Application No: FG/176/21/PL
Site Address: 78A Langbury Lane Ferring BN12 6QE
Description of works: Extensions to front parking. This site is in CIL Zone 4 (Zero Rated) as other development.

Thank you for your internet representation made on 10th November 2021 which has been recorded as an objection with the comments as follows:

REV	DATE	AMENDMENT	BY
PROJECT 78 LANGBURY LANE FERRING, WORTHING SUSSEX. BN12 6QE			
DRAWING EXISTING and PROPOSED SITE PLAN			
Date Sept 2021	Drawn By PJC		
Scale 1: 200 @A3	Iss. App. By DKC		
Drawing No 201	File Location 0247

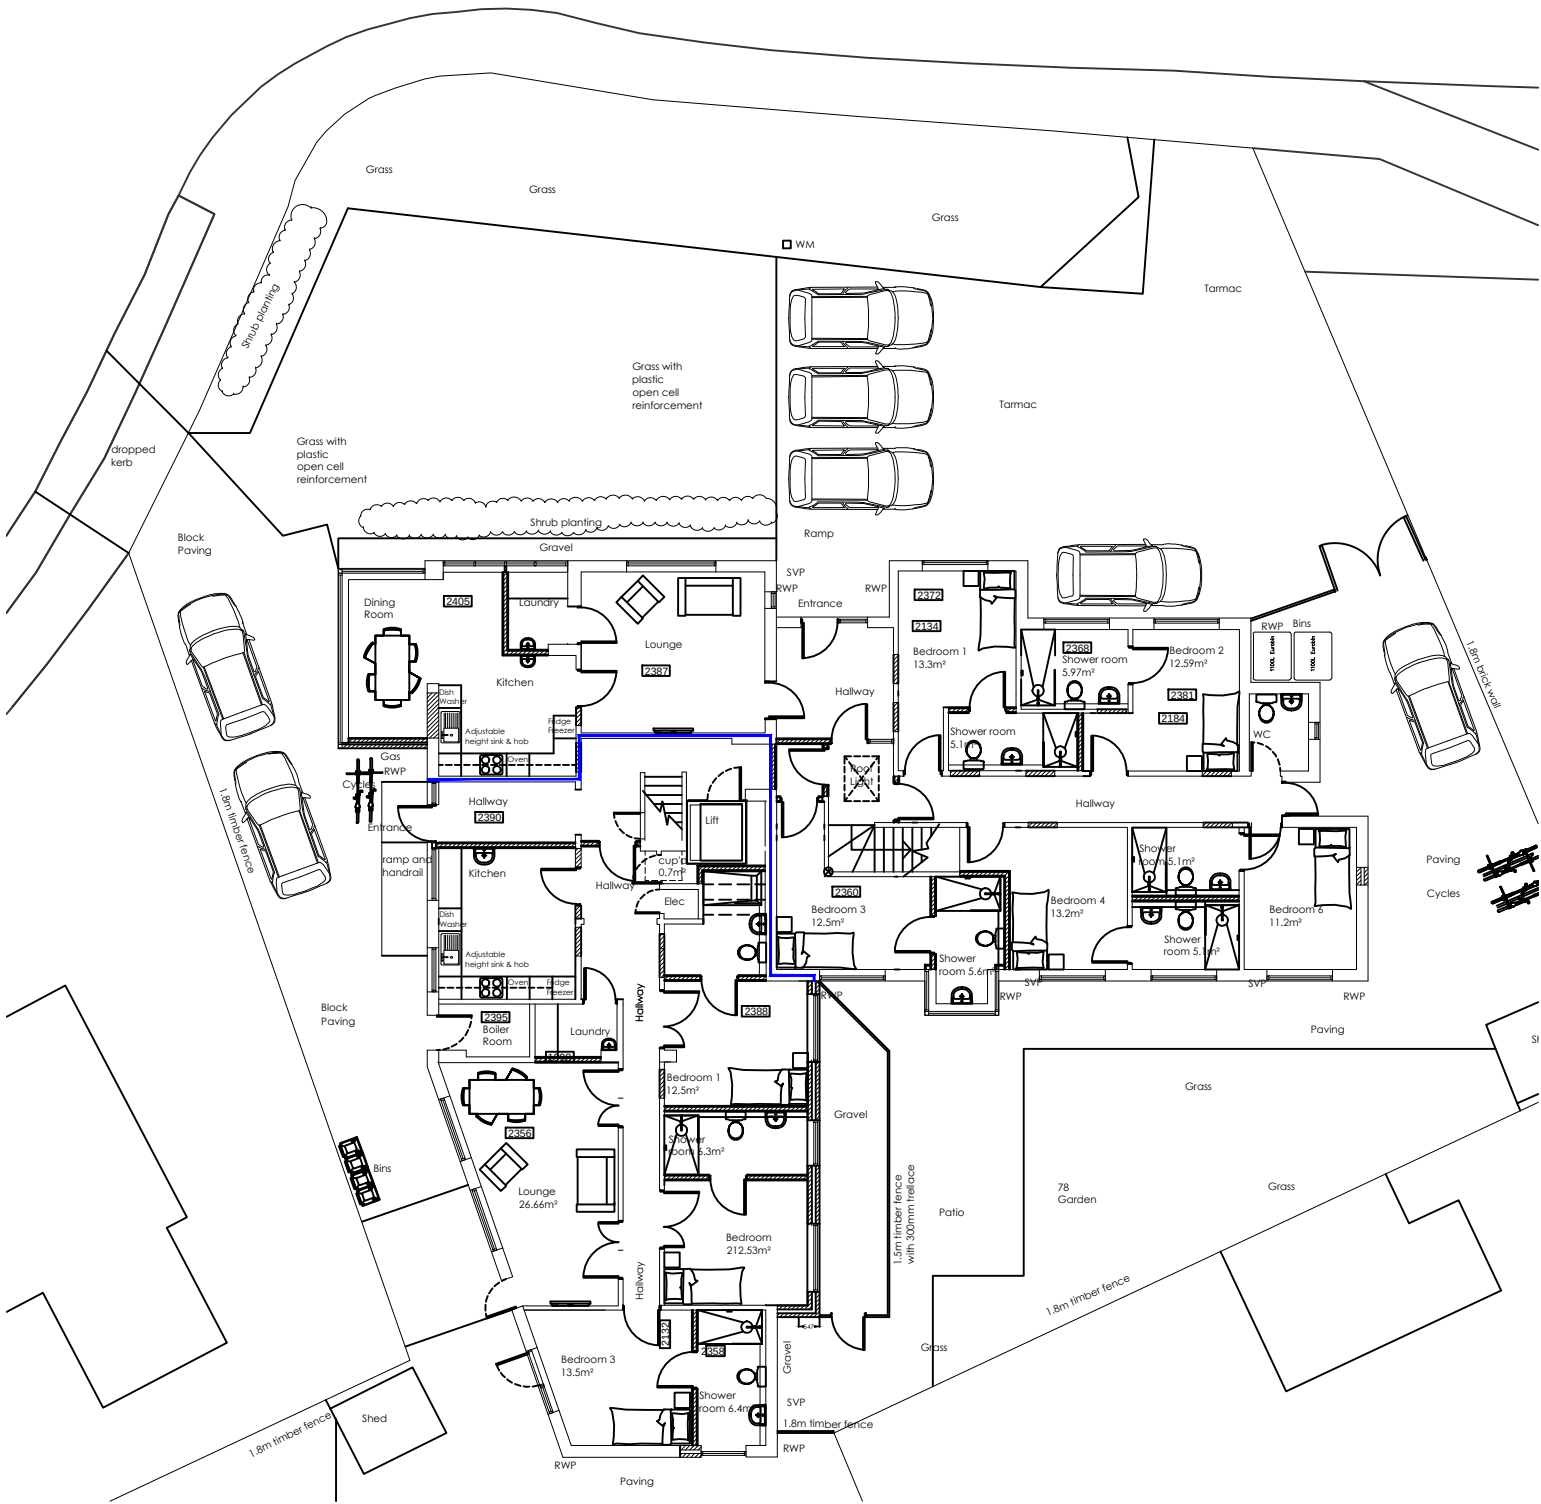
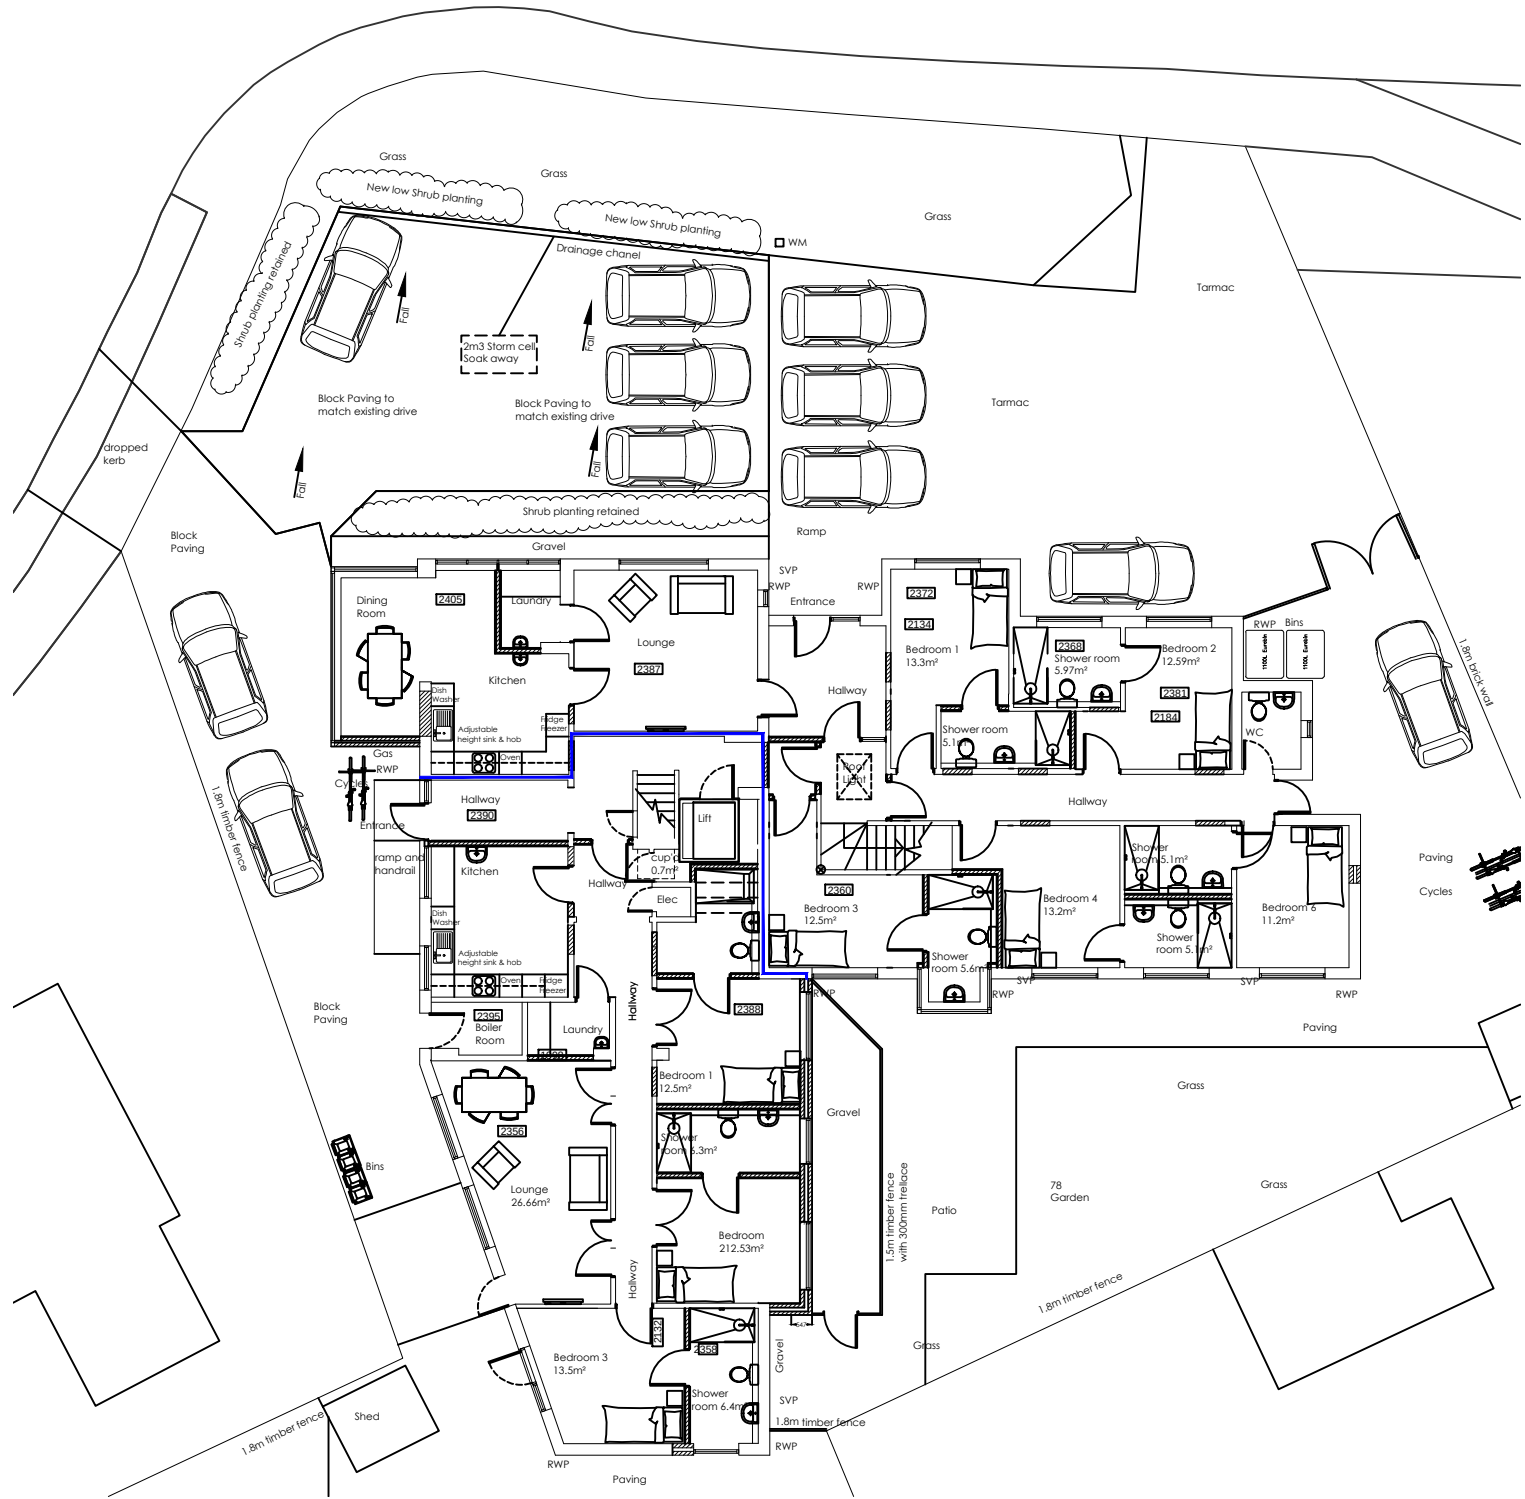
1. Not being able to get a clear and safe view of traffic travelling along Langbury Lane. This is extremely hazardous for cars and pedestrians that are turning in and out of the said junction.
2. There would need to be a small wall between the pedestrian pathway and the end of where it extends to, as the pathways are not wide; considering the area is used by elderly/disabled users and parents with prams.
